Fleurie Nursery, Lake Lane, Barnham
Drainage system - Annexe

1a - ADC Drainage Officer Recommendation and requirements

20.6.2022

WA/75/22/DOC

Exceedance routes

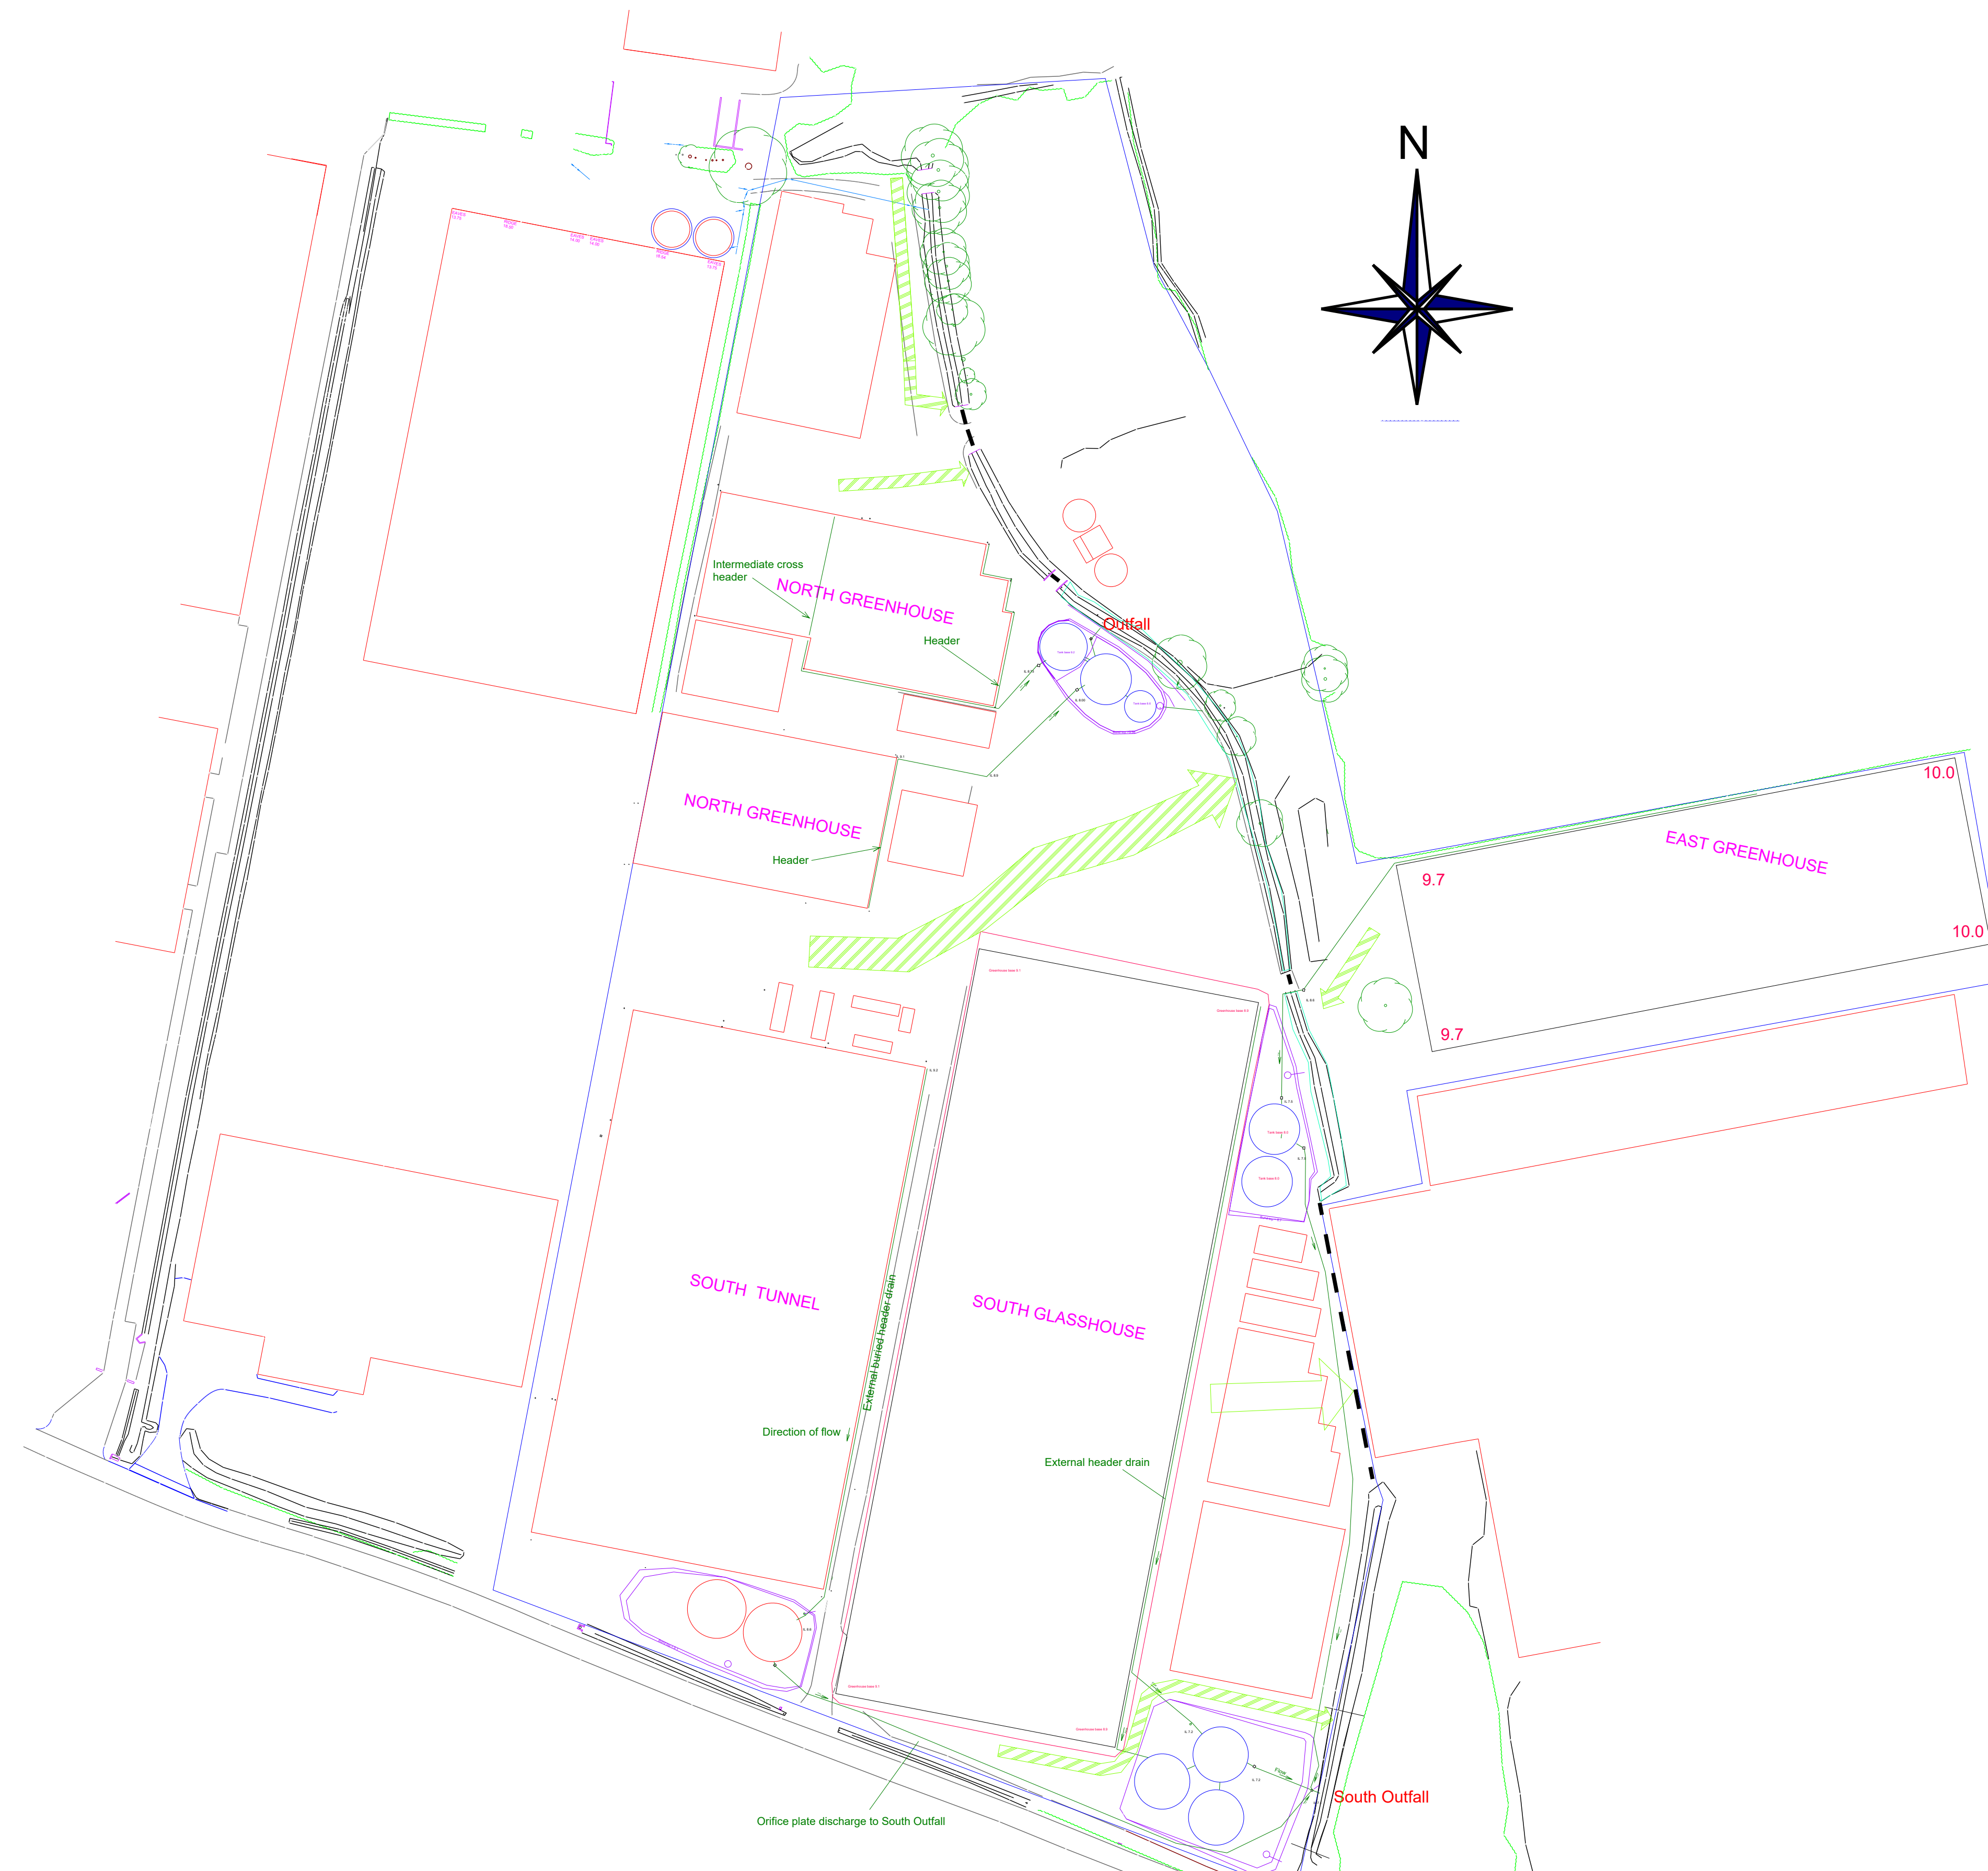
7) We have previously requested information relating to exceedance events and possible failure of the tanks. Given the large volumes of storage involved we would expect details of the exceedance flow routes and safety practices to be carried out to protect on and offsite occupants from the potential failure of the tanks.
